Consultation Response from: KC Environmental Health (Pollution & Noise Control)		
2021/90517 - Former Calder Works, Thornhill Road, Dewsbury, WF12 9QQ		
Discharge of condition 8 (validation report) of previous permission 2015/92252 for erection of two storey offices, production facility and warehouse		
Date Responded: 21th April 2021	Responding Officer: Natalie Heaney	Responding Ref: WK/202104091
Condition 8 – Validation Report To discharge Condition 8, the following documents have been submitted: • An Interim Validation for Phase 1 Construction by Rogers Geotechnical dated 02 Dec 2020 (ref: J3112/15/E/V1) • A Geoshield Gas Barrier Verification Document dated 25th July 2017 (ref: GEO1006200/AC/D). Note that the Geoshield document is provided in the same pdf document as the Rogers report. I have read the reports provided. The Rogers report details the validation carried out as part of the first phase of development. The site plan shows the goods yard sited off Thornhill Road with the portal framed structure located towards the front part of the site. A portion of the site behind the structure is annotated as an ecology buffer zone and outdoor rest area. The report details that the g

Photo 1 - showing detail to both pipe penetration and Stanchion base.

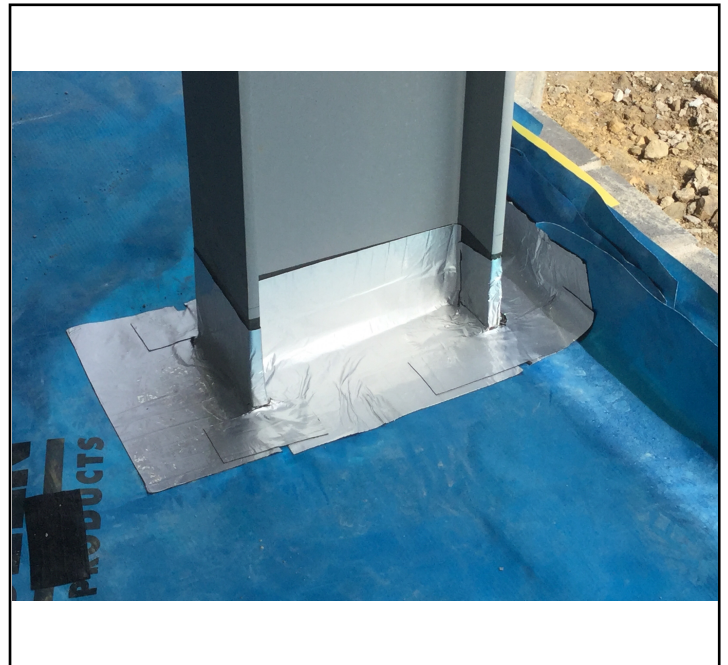
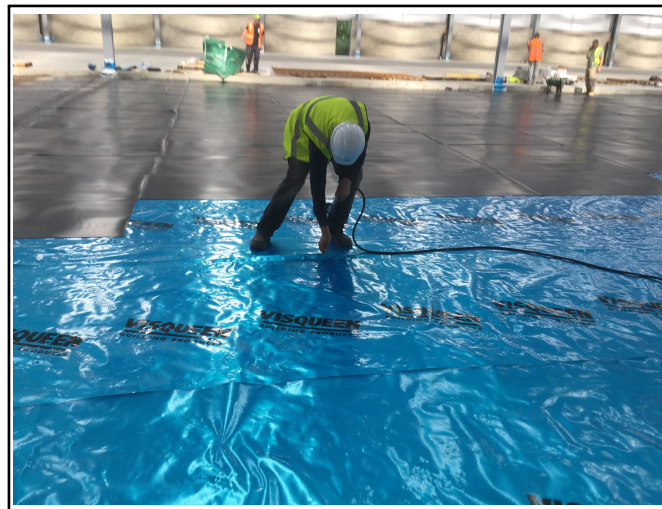
(2) The Geoshield Gas Barrier Verification Document (ref: GEO1006200/AC/D) identifies several insufficiencies such as incorrect stanchion and pipe penetration detailing and insufficient sand blinding which may cause punctures to the gas membrane. These would render the gas protection inadequate. It is unclear in the report what Geoshields conclusions are. Subsequently, it is also unclear whether the gas protection elements meet the agreed criteria and how the Rogers report (ref: J3112/15/E/V1) concluded that the gas membrane has been installed correctly. Further information is needed to clarify the installed gas protection elements at the site.
